### **Application by Five Estuaries Offshore Wind Farm Limited (“the Applicant”) for an Order granting Development Consent for the proposed Five Estuaries Offshore Wind Farm (“Project”)**

The following constitutes Natural England’s formal statutory response to the Secretary of State’s Request for Information (RFI) dated 11 July 2025. To inform this response Natural England have reviewed the following documents submitted into Examination by the Applicant:

*10. Natural England is invited to comment on the modified 2km buffer zone around the Outer Thames Estuary SPA, as proposed by the Applicant in Section 3.3 of the Working in Proximity to Wildlife in the Marine Environment [REP8A-013].*

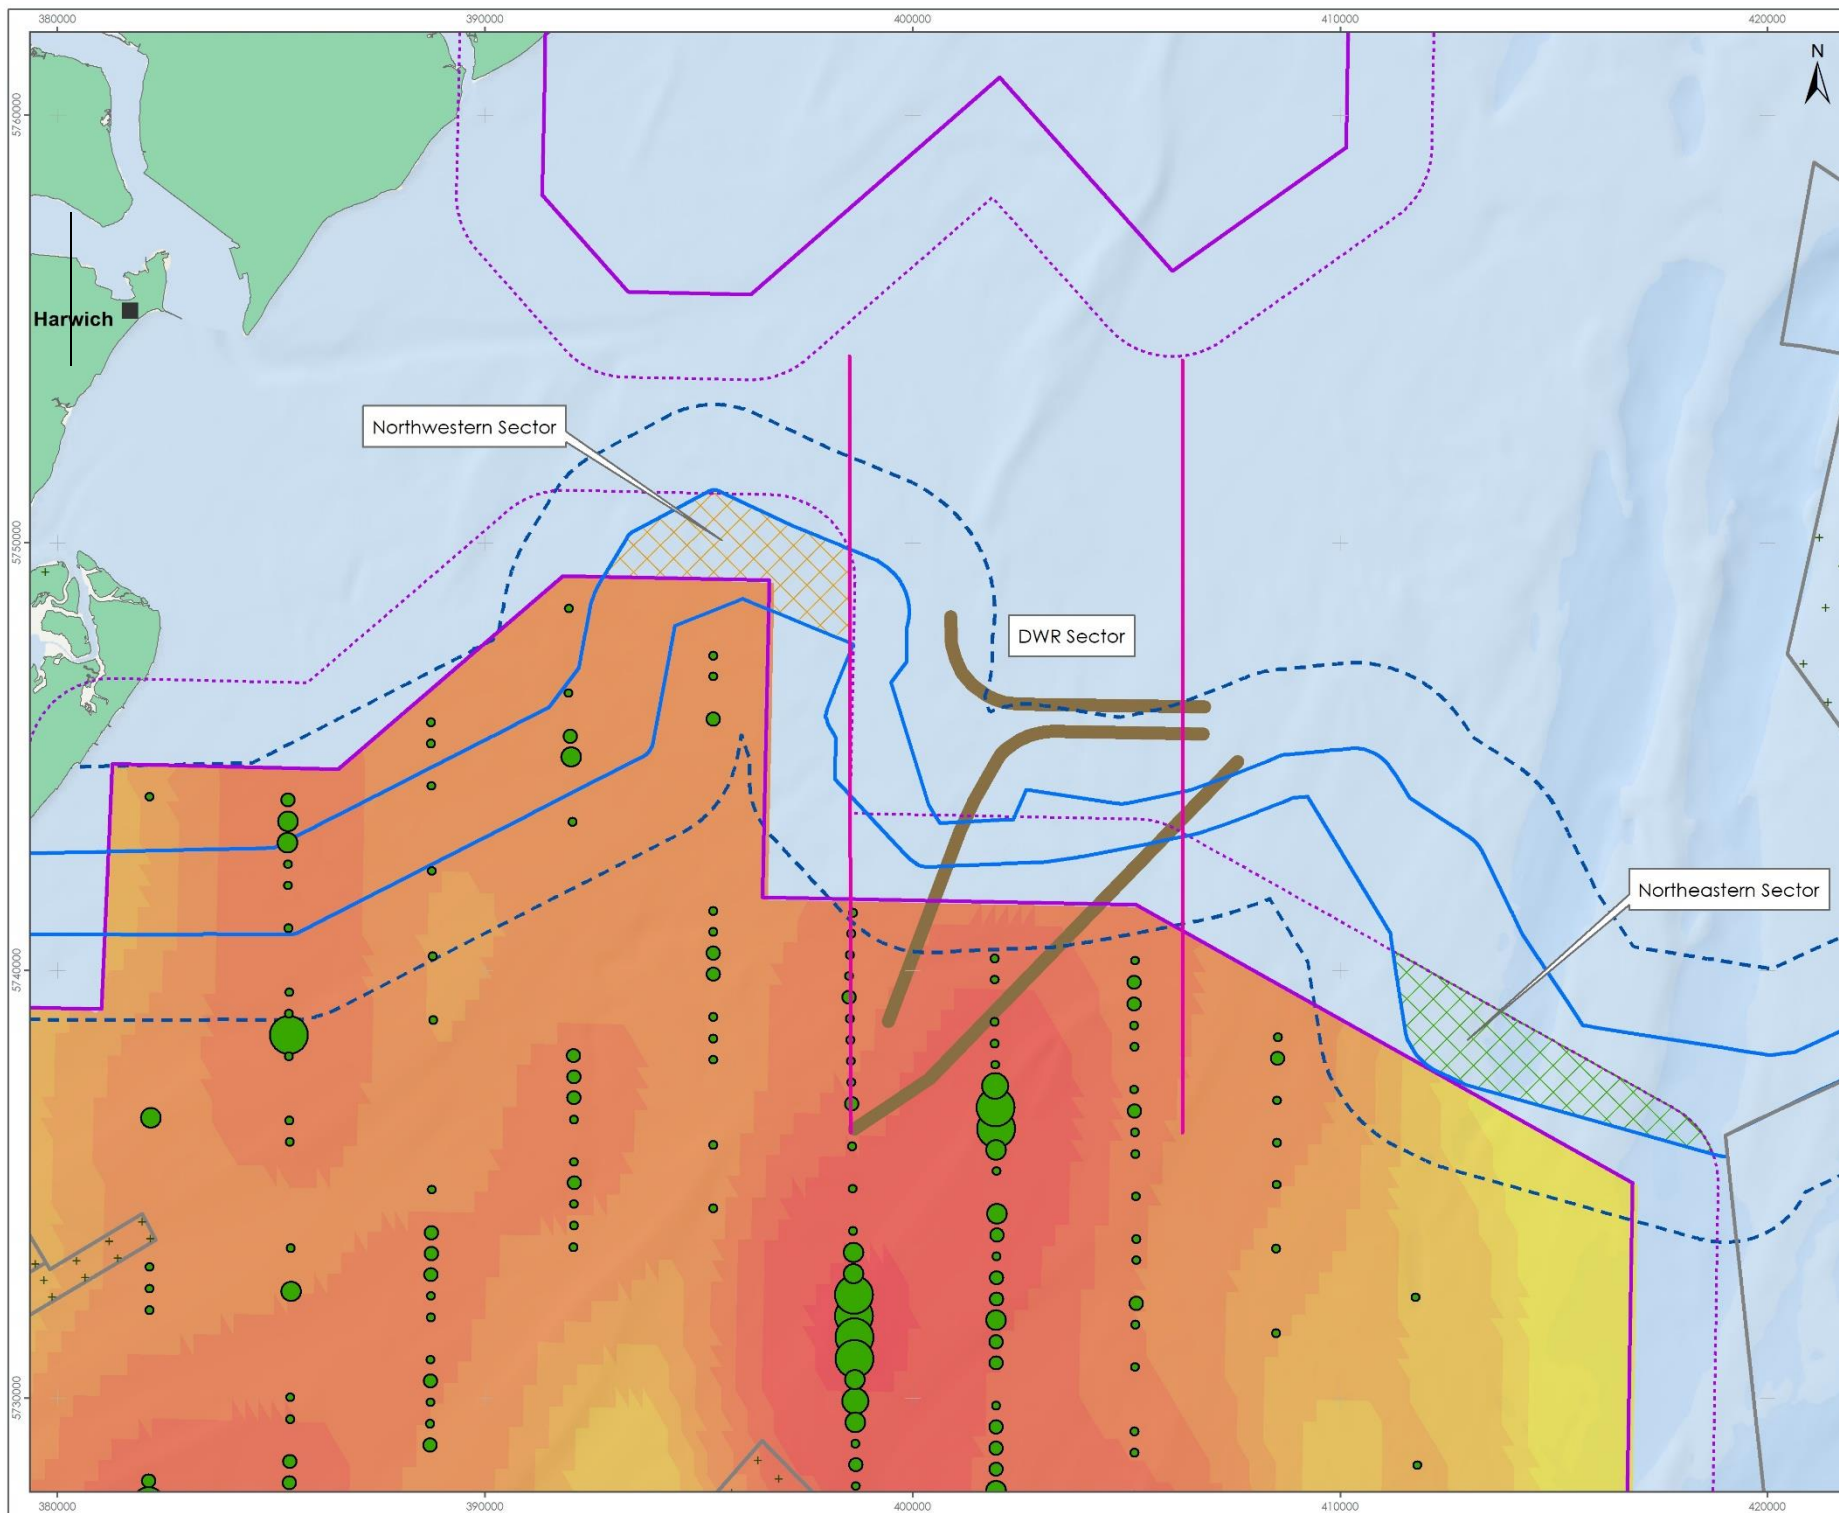
During this meeting we were able to highlight that work in the 2 km buffer of the central sector of the export cable corridor (ECC) would likely have the most impact. Natural England’s opinion is that work to lay cables within the SPA and its 2km buffer in the stretch west of the Trinity Deep Water Route (DWR) and across the Sunk DWR would be of principal concern and therefore needed the most judicious mitigation possible.

During the ETG we suggested one way to resolve the issue would be to only impose the seasonal restriction within the ECC west of the Trinity DWR (and apply vessel best practice elsewhere), but it was unclear how disruptive to operations this would be. In other words, whether it would be feasible to install the stretch of cable west of the Trinity DWR to shore entirely outside of the seasonally restricted period (i.e. between 01 April to 31 October). Should this be feasible it would provide an acceptable resolution, minimising disturbance to RTD not only where the cable route crosses the SPA directly but also in the higher diver density zones around the DWR routes where the cable route passes within 2km of the SPA boundary.

- Whilst the intentions are welcomed, we do not consider only working on one DWR at any time will make any difference to disturbance on RTD in the SPA. This is because the cable route across the Trinity DWR lies outside the SPA 2km buffer anyway.

- Laying cables within the restricted period but limited to 3 months is also unlikely to reduce impacts enough, because it would still limit the birds' use of the SPA during the sensitive winter period for long enough to potentially cause harm.

- It is also unclear if the 3 months of work proposed would occur in a single period or intermittently, spread over the entirety of the sensitive season.

- Carrying work out in vessel clusters would be helpful, but in the context of a 3-month duration would not in and of itself avoid significant impacts.

- Offering to work outside of the seasonally restricted period (01 November-31 March, inclusive) **only if feasible** provides insufficient reassurance or commitment to the task and therefore cannot be meaningfully factored into the impact assessment.
